HISTORIC PRESERVATION BOARD

Re: 44 Oak Street – Rooftop pergola and planters
CBL: 039 B011

On June 21, 2017, Portland's Historic Preservation Board voted 7-0 to approve your after the fact application to construct a rooftop pergola and planters on the flat roof of your unit at 21 Pine Street. Approval is based on the specifications and information provided for the public hearing held on June 21, 2017, and is subject to the following conditions:

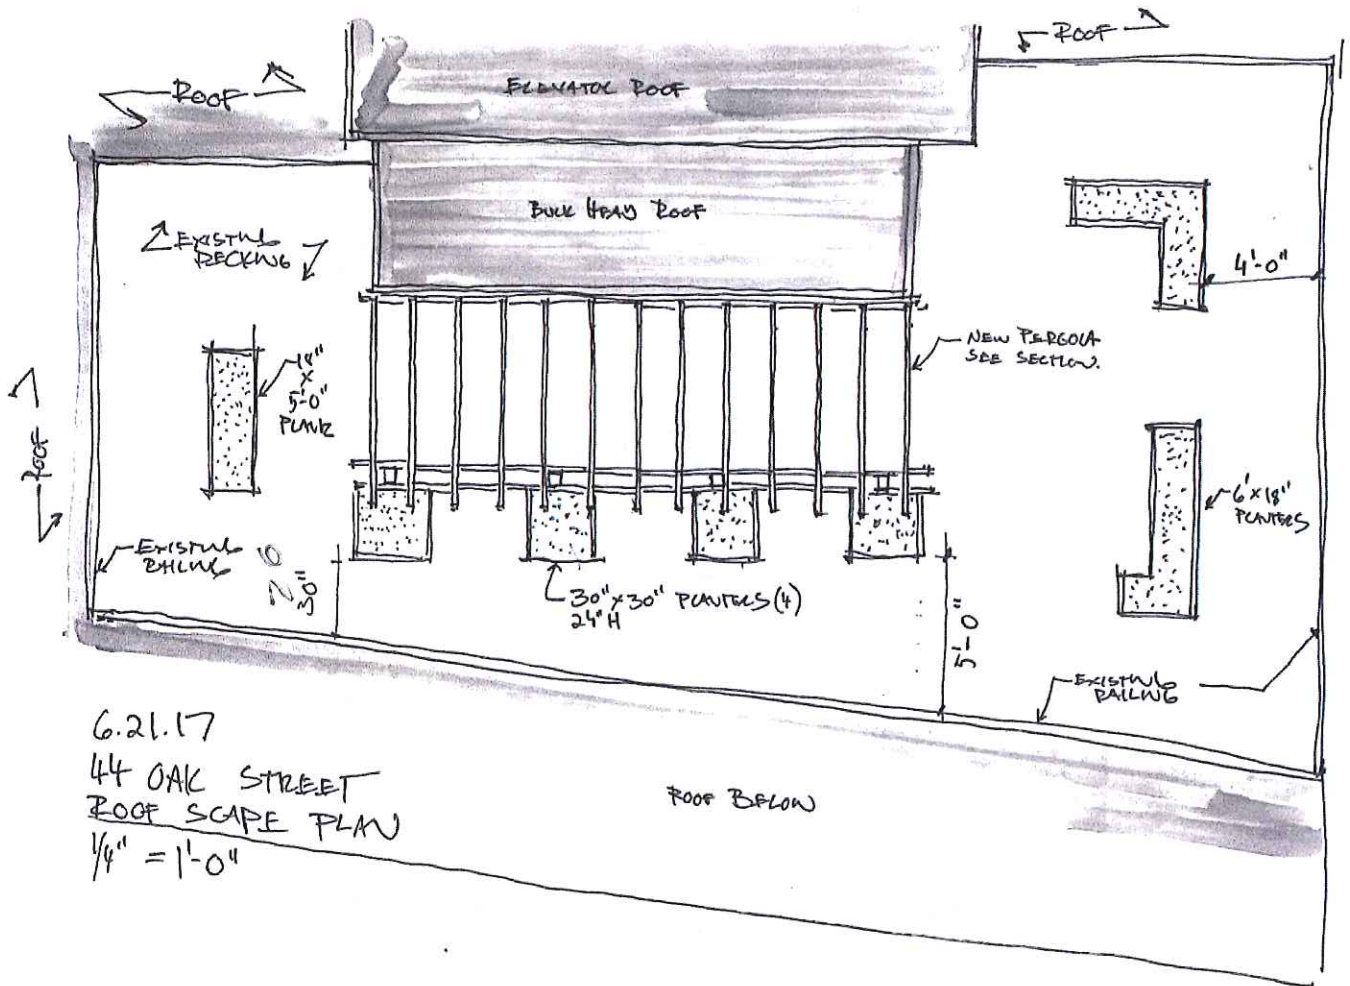
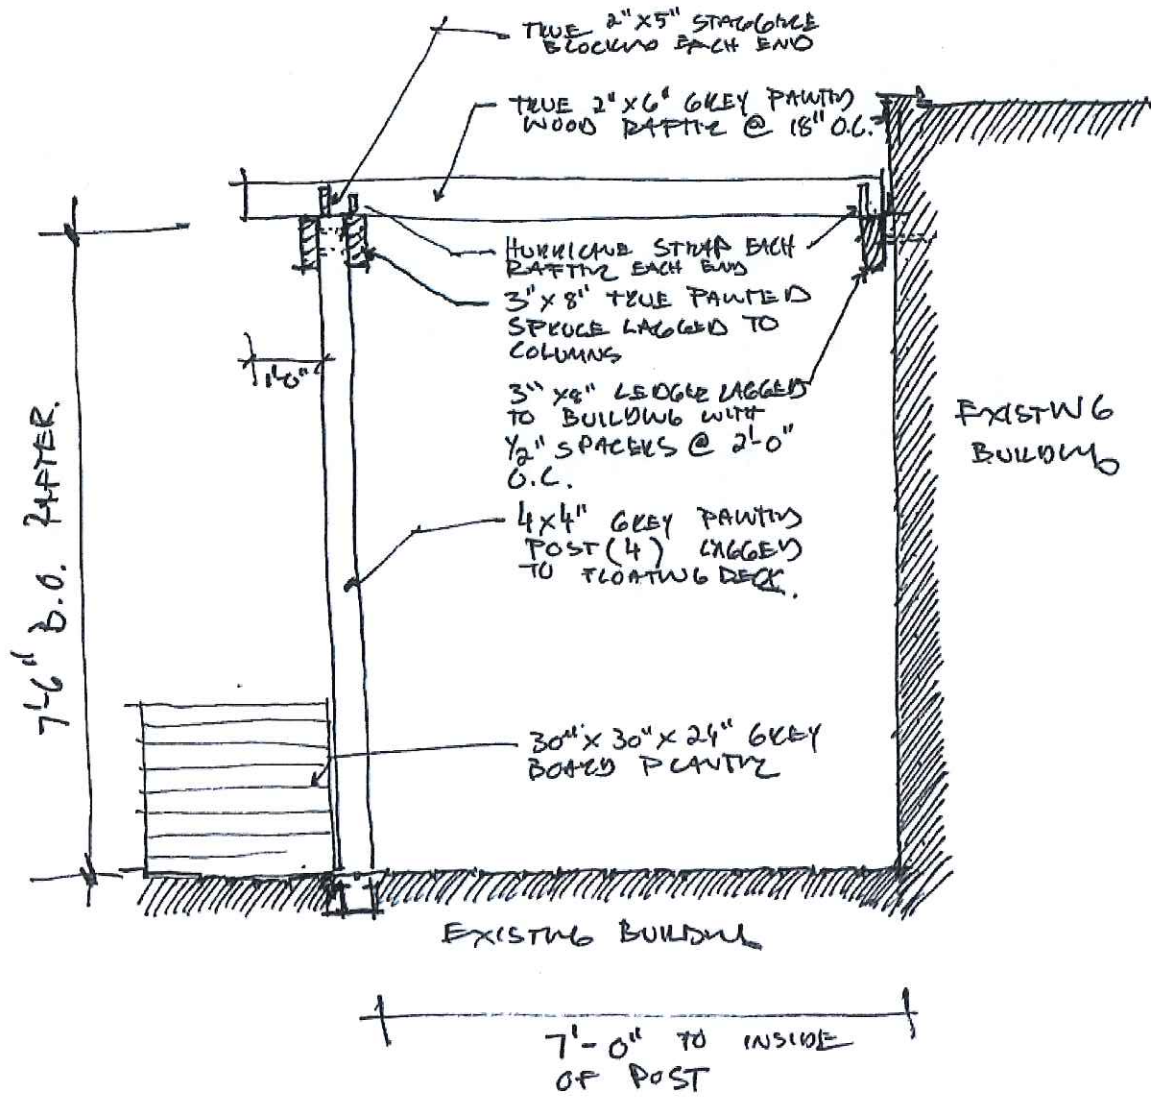
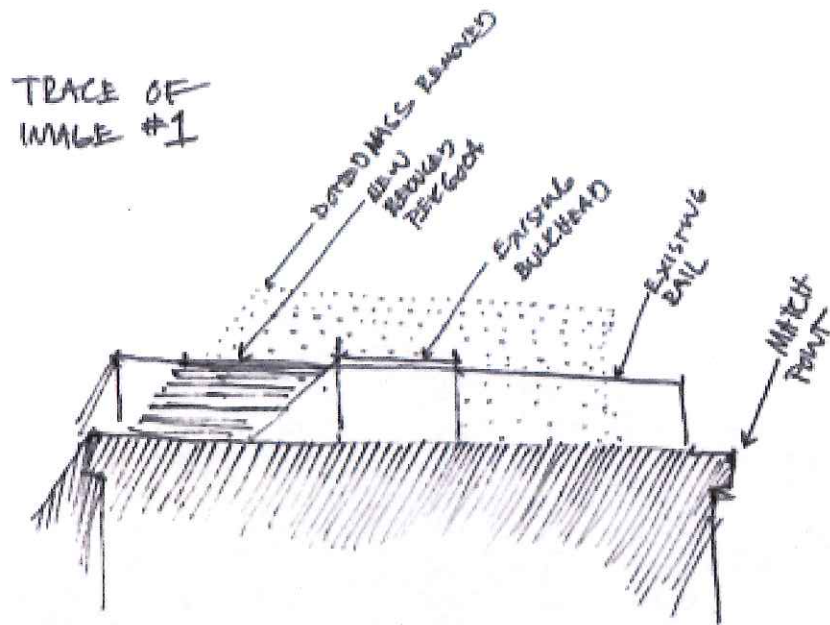
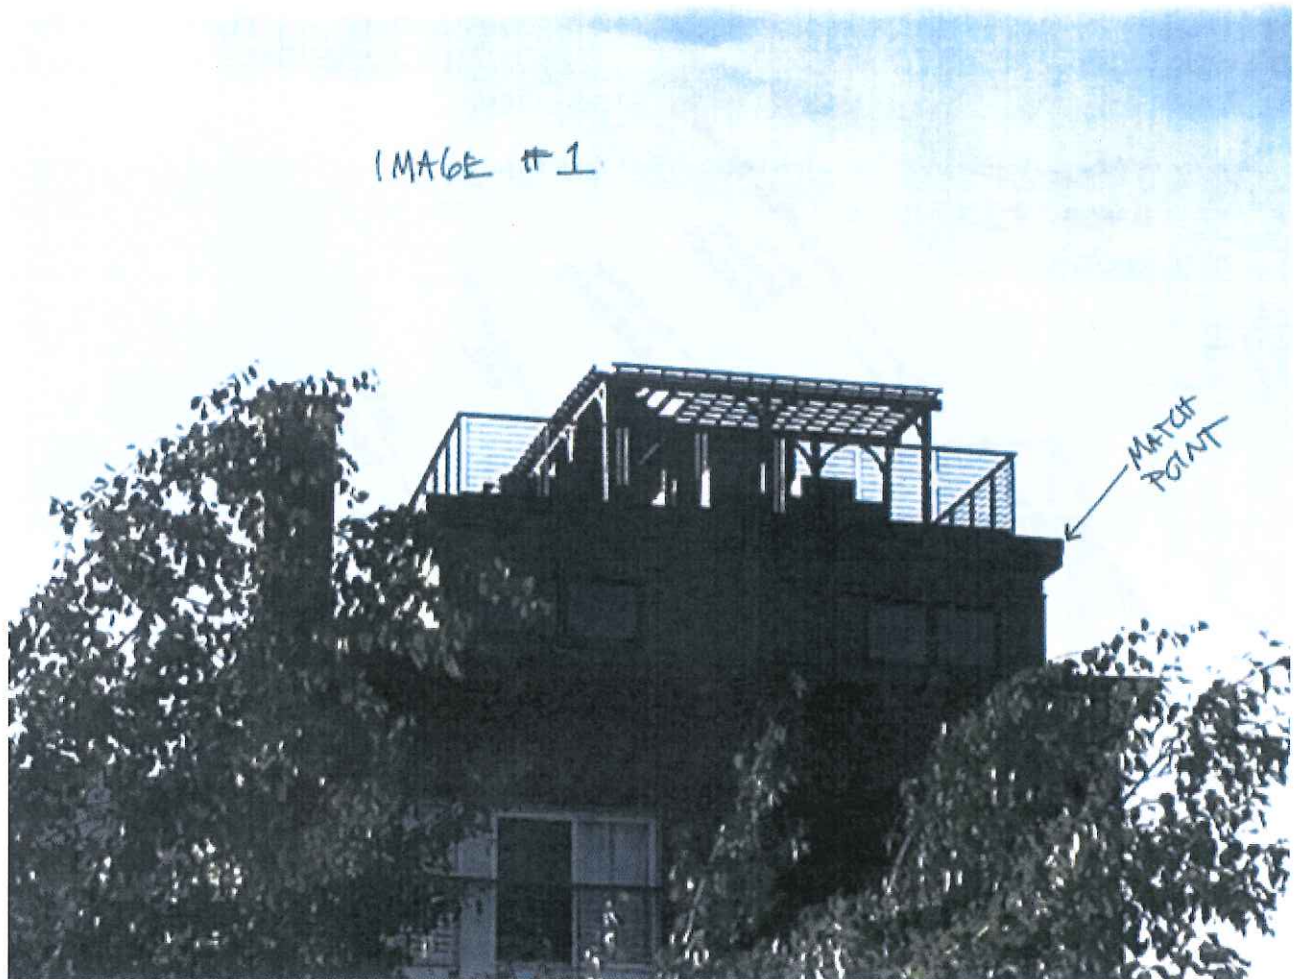
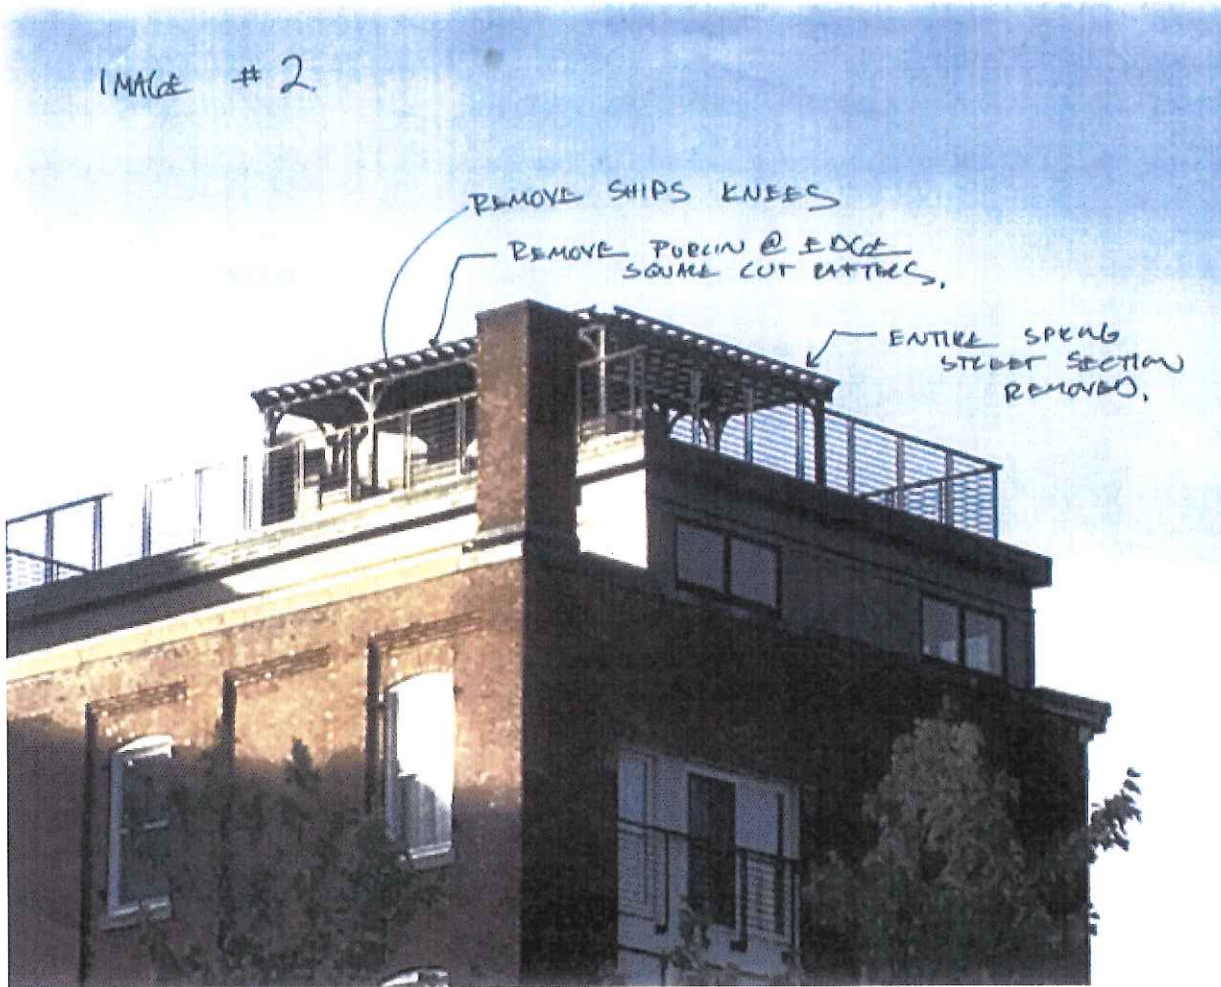
- Approved pergola design is the simplified and scaled back revision presented at the 6/21/17 Board hearing: 7' x 18', painted charcoal to match the stair bulkhead.
- The applicant is responsible for obtaining all required permits, including a building permit.
- Planters that are at least 4' from the railing shall be a maximum of 30" high. Planters located between 30" and 48" from the railing shall not be taller than 24" high. No planters are to be closer to the railing than 30".
- At no time shall the height of plants exceed 5' from the deck.
